CITY OF ALBUQUERQUE

RE: **Buddhist Temple**
Grading and Drainage Plan
Engineer's Stamp Date 11-11-16 (File: K17D112)

Based upon the information provided in your submittal received 12-28-2016, the following comments need to be addressed for approval of the Building Permit:

C-101

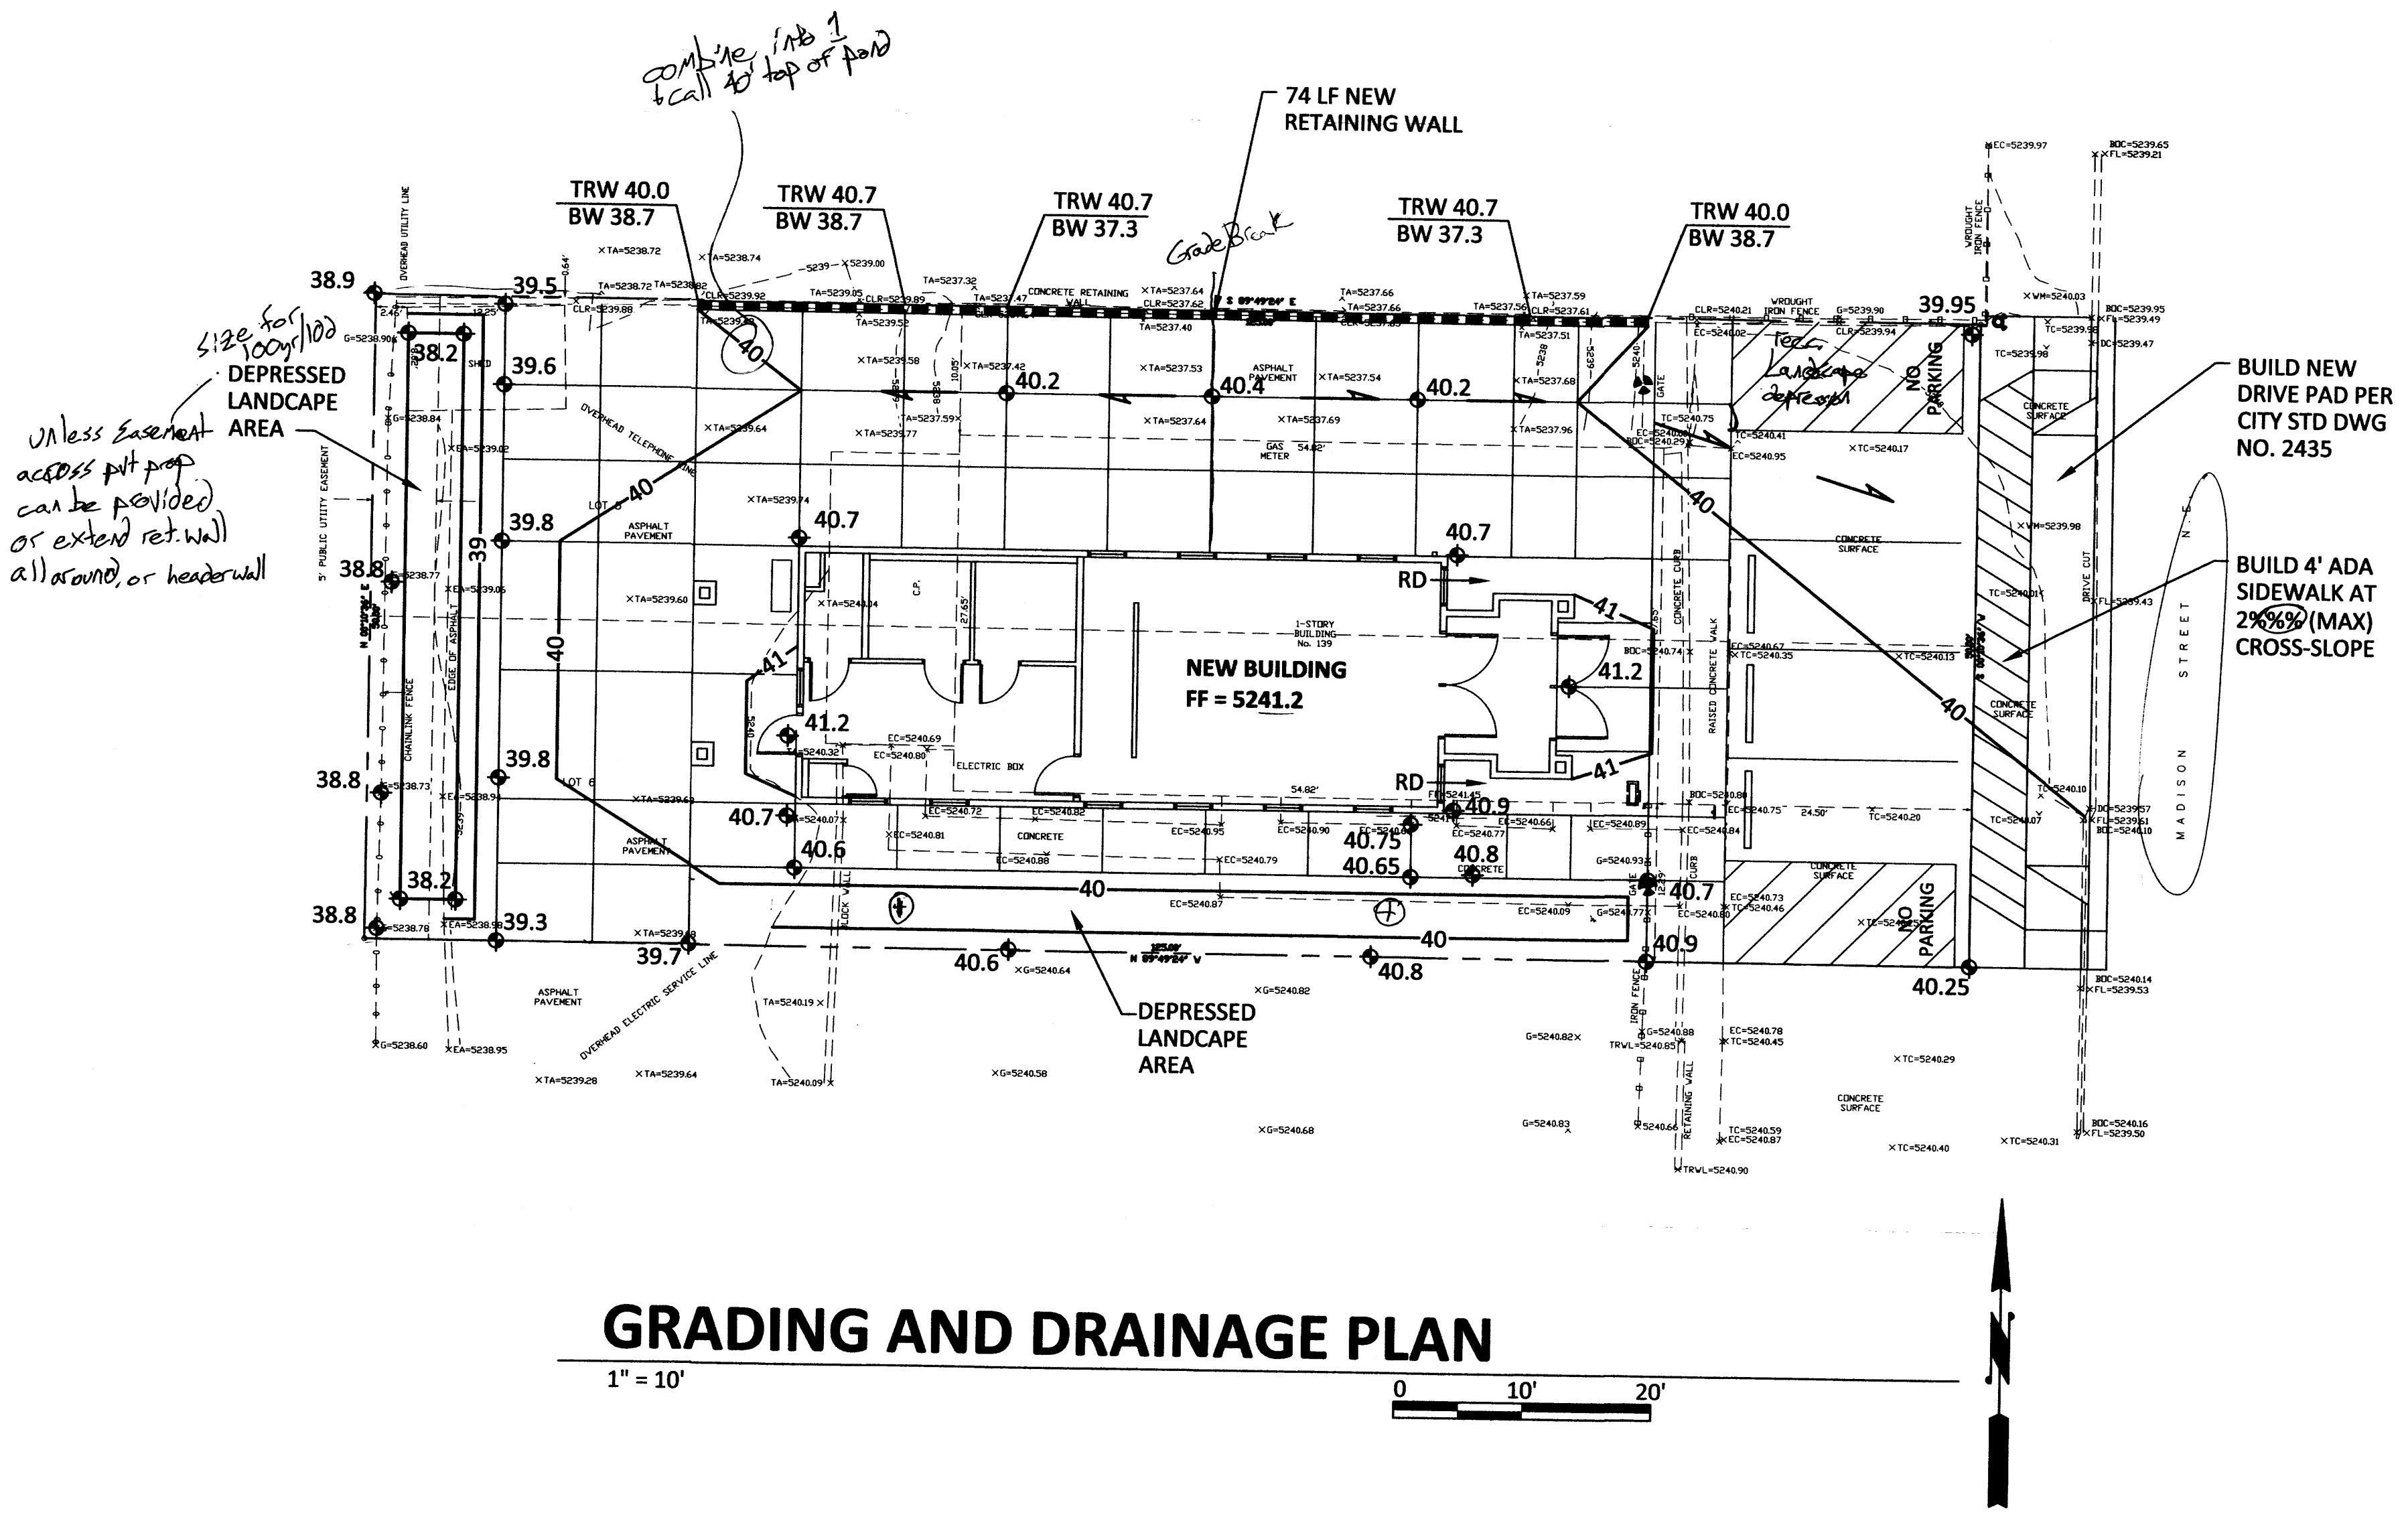
1. The Drainage Approach currently states that all flows are to be conveyed *west* to the existing drive pad. The only existing drive pad is to the *east* on Madison Street, is this the referred to drivepad?

2. As shown on the drawing, a north-south grade break roughly bisects the lot, sending some flow east towards Madison Street and some flow west towards the back of the lot. The area flowing toward the back of lot will need to be detained on-site for the 100-year, 10-day storm event. Several measures are recommended to accomplish this:

- a. A short (approximately 18" high) header wall may be placed along the back of the lot and waterproofed in order to raise the ponding depth to 5240'. This will increase ponding area and depth, while remaining at least one foot below the finished grade of the slab.

- b. The proposed depressed landscape areas may be widened, deepened and combined into one to contain a greater volume.Supporting calculations would be needed if an above option is selected. Options that would not require detaining the 100-year, 10 day storm include:

- a. Regrading the lot to convey all flows towards Madison Street. This will likely require raising the finished grade of the building slab.
 - b. A private drainage easement with the adjoining lot may be negotiated to convey flows to either Copper Avenue or Jefferson Street.

1. Provide finished grade spot elevations for bottom of depressed landscape areas.

2. Correct build note "...2%% (max) cross-slope."
3. 4x font on "Madison Street" label

Although not required, the areas labelled "no parking" may be left as crusher-fines or converted to landscaping with westward flows routed through them to decrease impervious area. If you have any questions, please contact me at 924-3695 or dpeterson@cabq.gov.
